## ***Rezoning Petition Review***

**Rezoning Petition #:** 20-167

**Location of Property:** Approximately 3.08 acres located on the west side of Bancroft St, north of 24<sup>th</sup> St and east of Graham St.

SCHEMATIC  
SITE PLAN  
SCALE: 1" = 30'

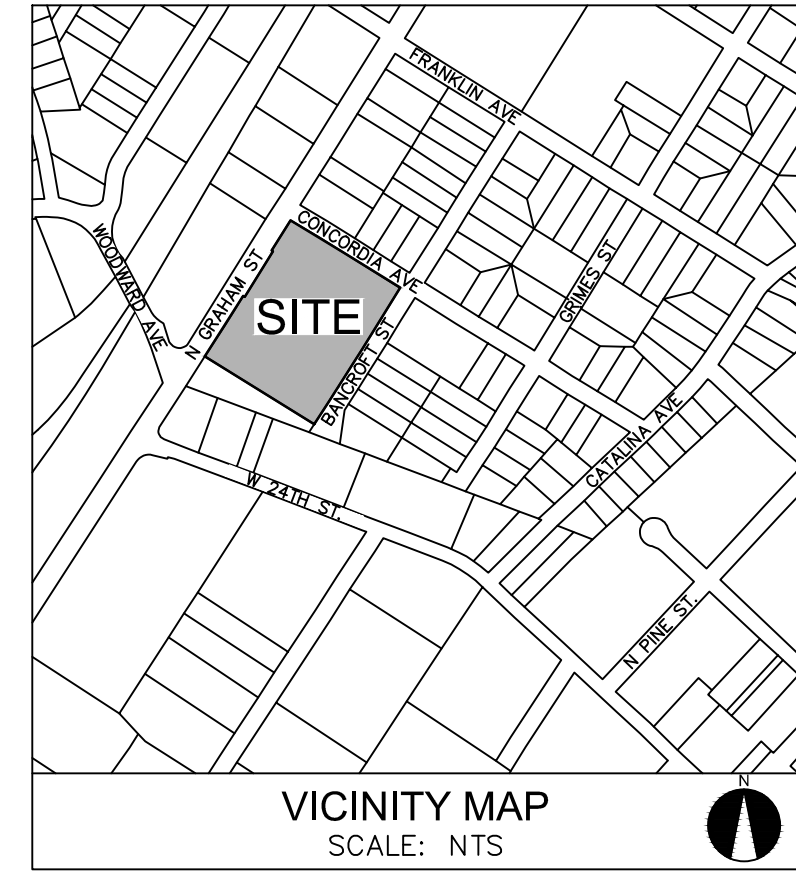
**This property drains to Upper Little Sugar Creek, which is an impaired/degraded stream, and may contribute to downstream flooding. This project has the opportunity to mitigate future impacts to this stream, therefore, Storm Water recommends placing the following notes on the plan:**

For defined watersheds greater than 24% built-upon area (BUA), construct water quality stormwater control measures (SCMs) designed for the runoff generated from the first 1-inch of rainfall for all new and redeveloped BUA associated with the project. SCMs must be designed and constructed in accordance with the Charlotte-Mecklenburg BMP Design Manual.

For defined watersheds greater than 24% built-upon area, control the entire volume for the 1-year, 24-hour storm for all new and redeveloped BUA associated with the project. Runoff volume drawdown time shall be in accordance with the Charlotte-Mecklenburg BMP Design Manual.

For commercial projects with greater than 24% BUA, control the peak to not exceed the predevelopment runoff rates for the 10-yr, 6-hr storm and perform a downstream flood analysis to determine whether additional peak control is needed and if so, for what level of storm frequency, or if a downstream analysis is not performed, control the peak for the 10-yr and 25-yr, 6-hour storms.

For residential projects with greater than 24% BUA, control the peak to not exceed the predevelopment runoff rates for the 10-year and 25-year, 6-hour storms or perform a downstream analysis to determine whether peak control is needed, and if so, for what level of storm frequency.
